**Application by National Highways for  
an Order granting Development  
Consent for the Lower Thames  
Crossing (Ref. No. TR010032)**

**Submission for Examination Deadline 9  
– 15 December 2023**

**Emergency Services & Safety Partners  
Steering Group (ESSP SG)**

**Comments on Applicant's  
submissions at D8**

# Mott Family Emergency Vehicle RVP Location

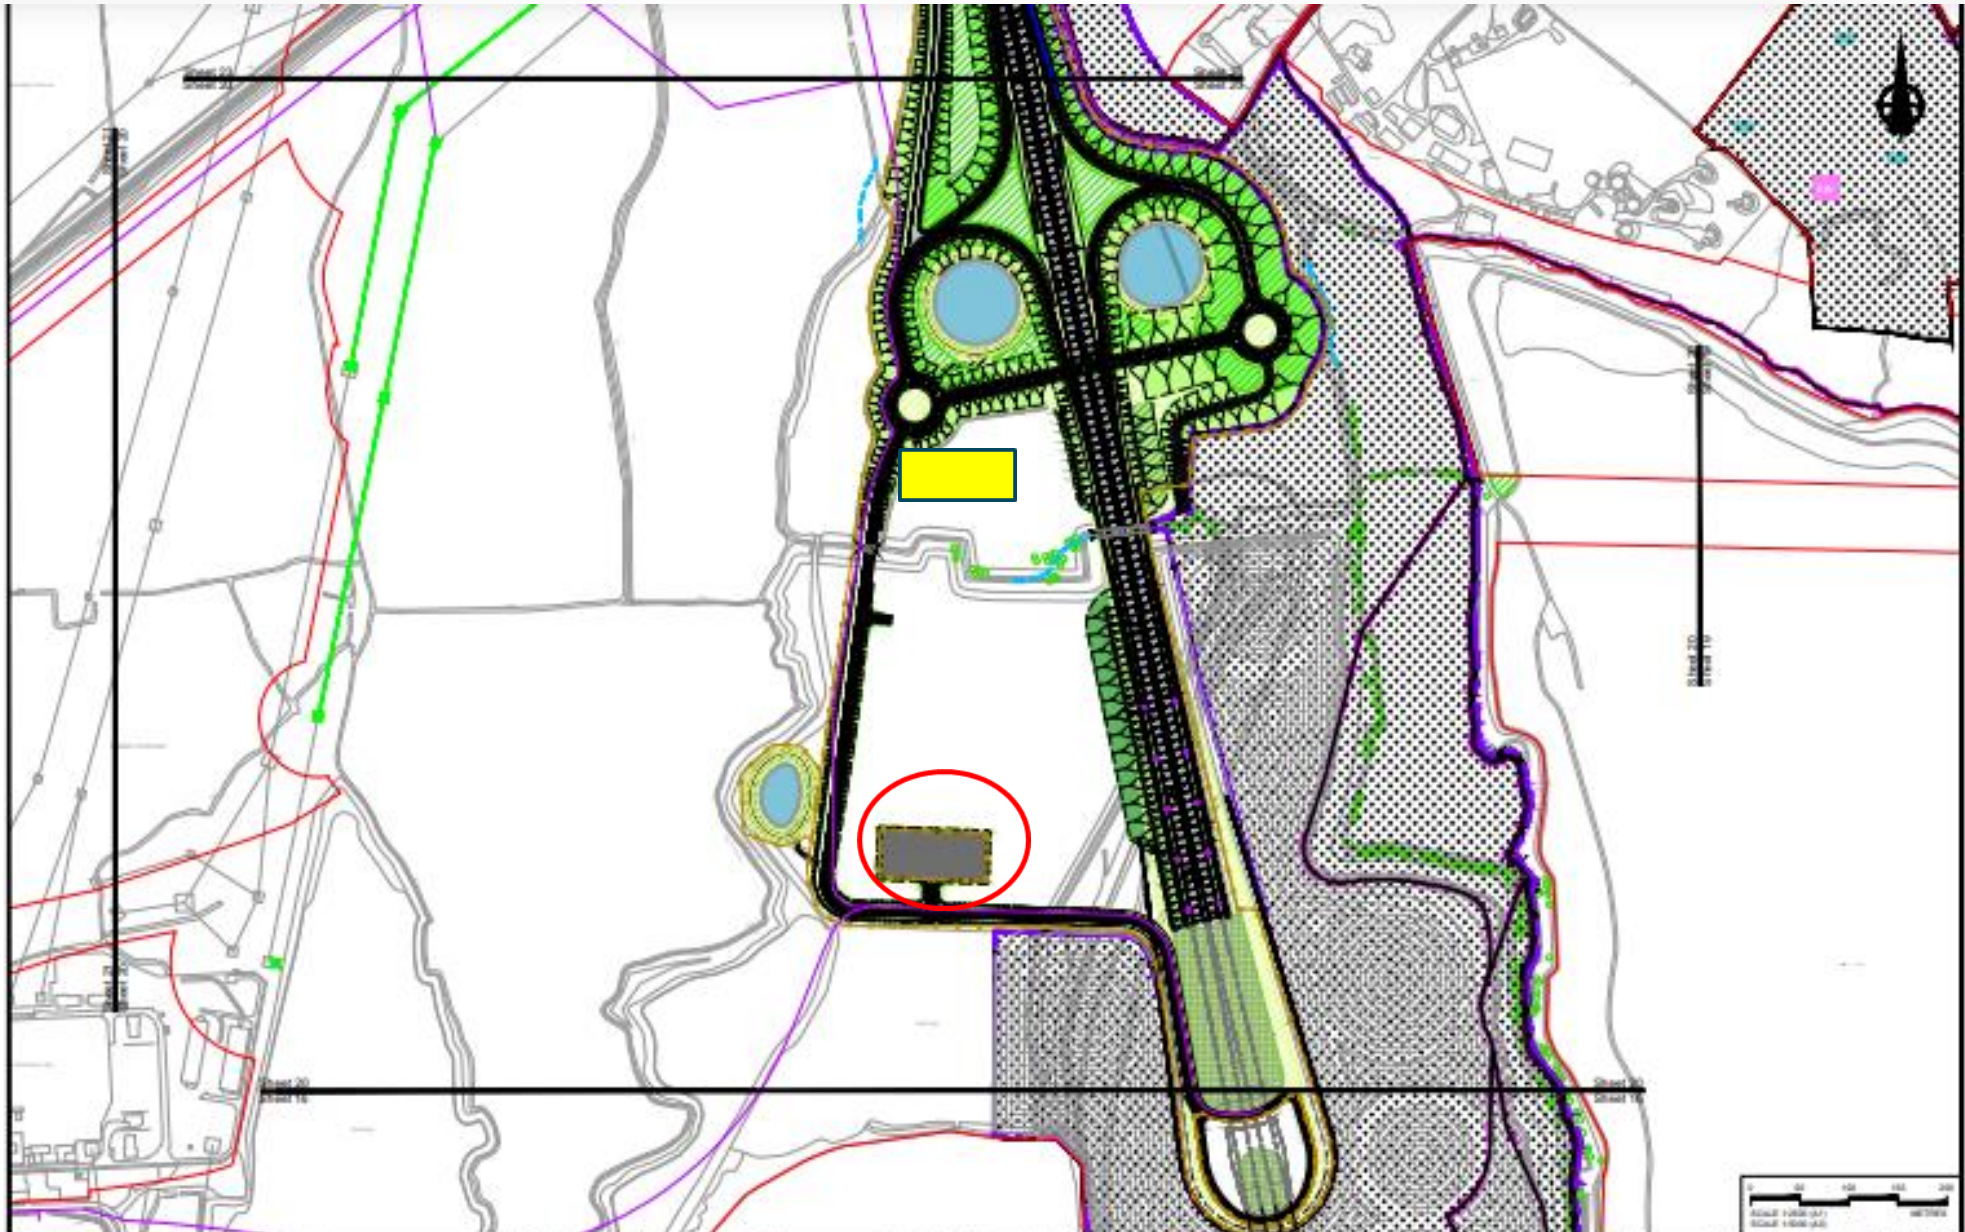
10. The ESSP SG position on the current scheme RVP north of the River Thames, (referred to as Work 5A(ix) of the dDCO ([REP8-007](#)) (dDCO); and shown on the preliminary scheme drawings, e.g. General Arrangement Plans Volume B (sheets 1 to 20) v4.0 Sheet 20 ([REP7-027](#))) is that it is unacceptable to the emergency services.

12. However, the ESSP SG is very concerned that the Applicant has declined to change the preliminary design in order to:
  - a) remove the current RVP proposal near the north tunnel portal, and

- a) revising the dDCO ([REP8-007](#)) to ensure that Work 5A(ix) of Schedule 2 refers to the alternative RVP proposal
  - b) changing sheet 20 of the Works Plans Volume B Composite (sheets 1 to 20) v5.0 ([REP7-039](#)) to remove the current RVP at the north tunnel portal and its Work No.5A label

- c) amend Works Plans Volume C Composite (sheets 21 to 49) v6.0 ([REP7-041](#)) to show the alternative RVP on sheet 24
  - d) changing General Arrangement Plans Volume B (sheets 1 to 20) v4.0 Sheet 20 ([REP7-027](#)), to delete the current RVP at the north tunnel portal

17. The ESSP SG’s position is that ideally a suitable RVP for the project to the north of the River Thames should be secured by removing references to the current RVP and replacing it with the alternative proposal shown in Appendix A of this submission. This would involve changes to the following documents:
